***RE: Grading and Drainage Certification Plan for The Enclave at High Desert, Tract 8C,
(E23/D3B1) Submitted for Release of Financial Guarantees, Engineer's Certification
Stamp Dated 6/20/00.***

**RE: *Revised Grading and Drainage Plan for The Enclave at High Desert, Tract 8C, (E23/D3B1)
Submitted for Final Plat Approval, Engineer's Stamp Dated 2/19/99.***

**DRAINAGE REPORT
FOR
THE ENCLAVE AT HIGH DESERT
(TRACT 8C)**

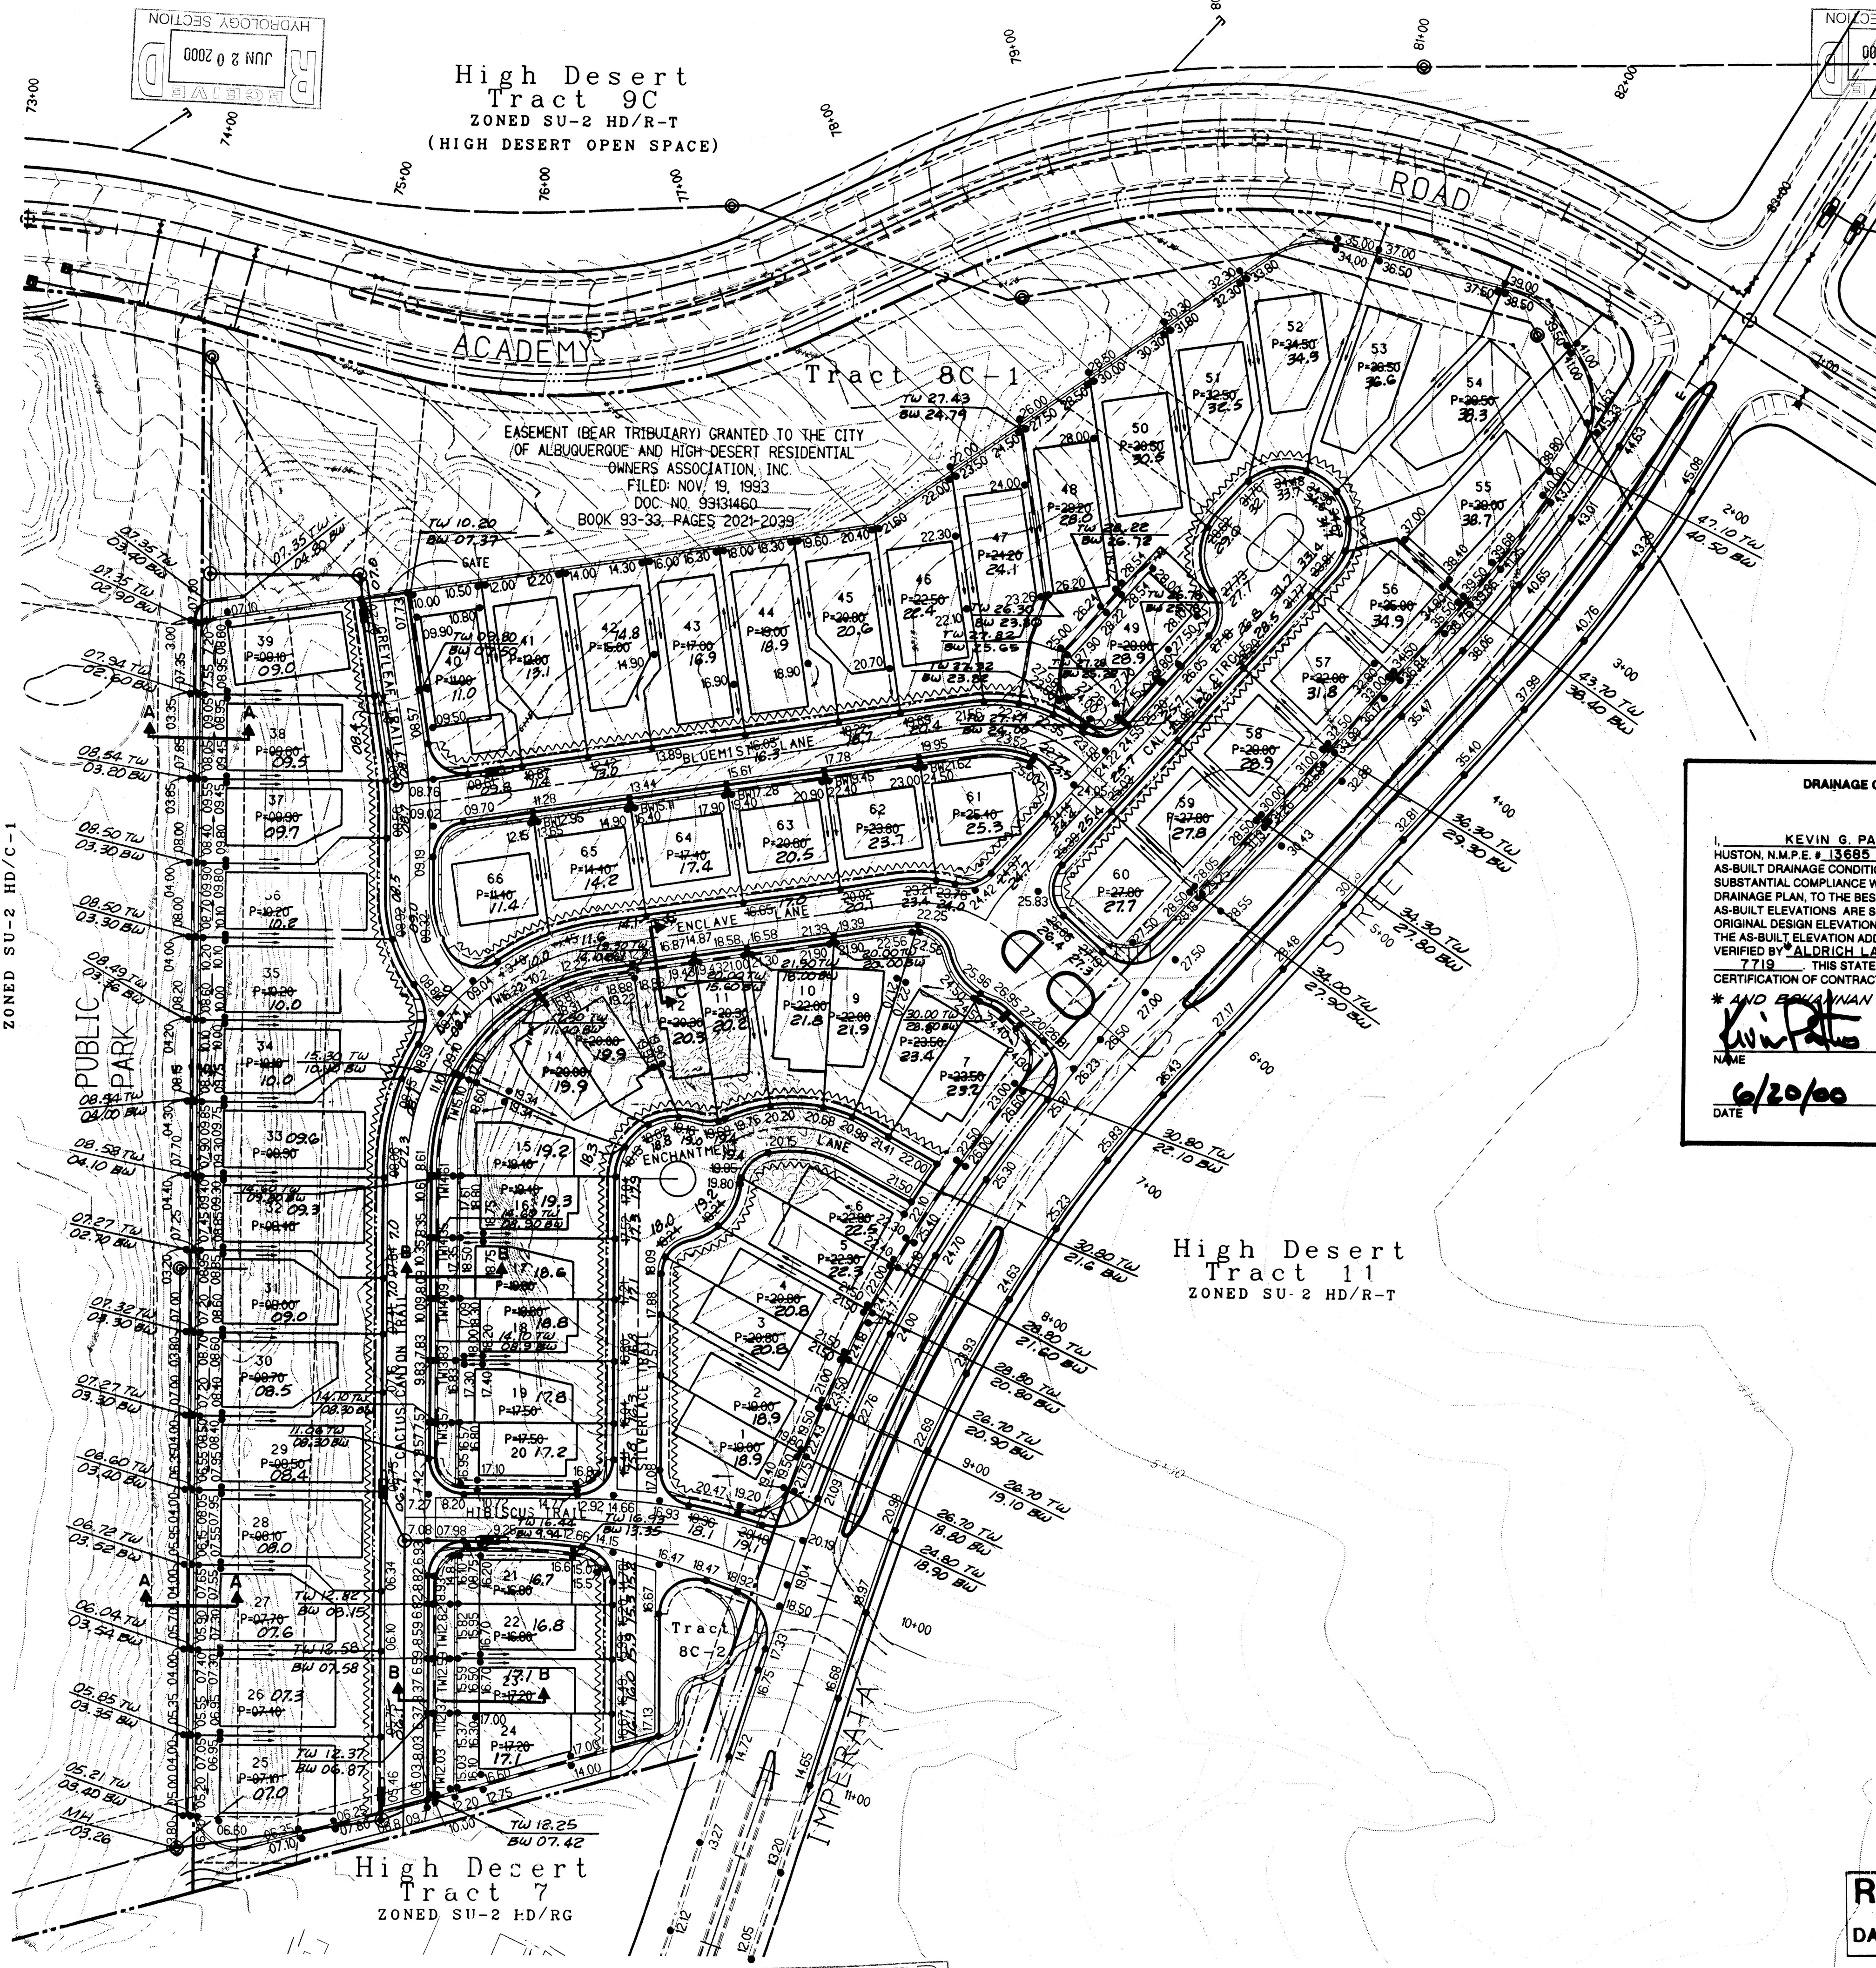
It appears that retaining walls are needed between Lots 42 and 43, and Lots 43 and 44. Please verify that these walls have been constructed on the Engineer's Certification for this subdivision.
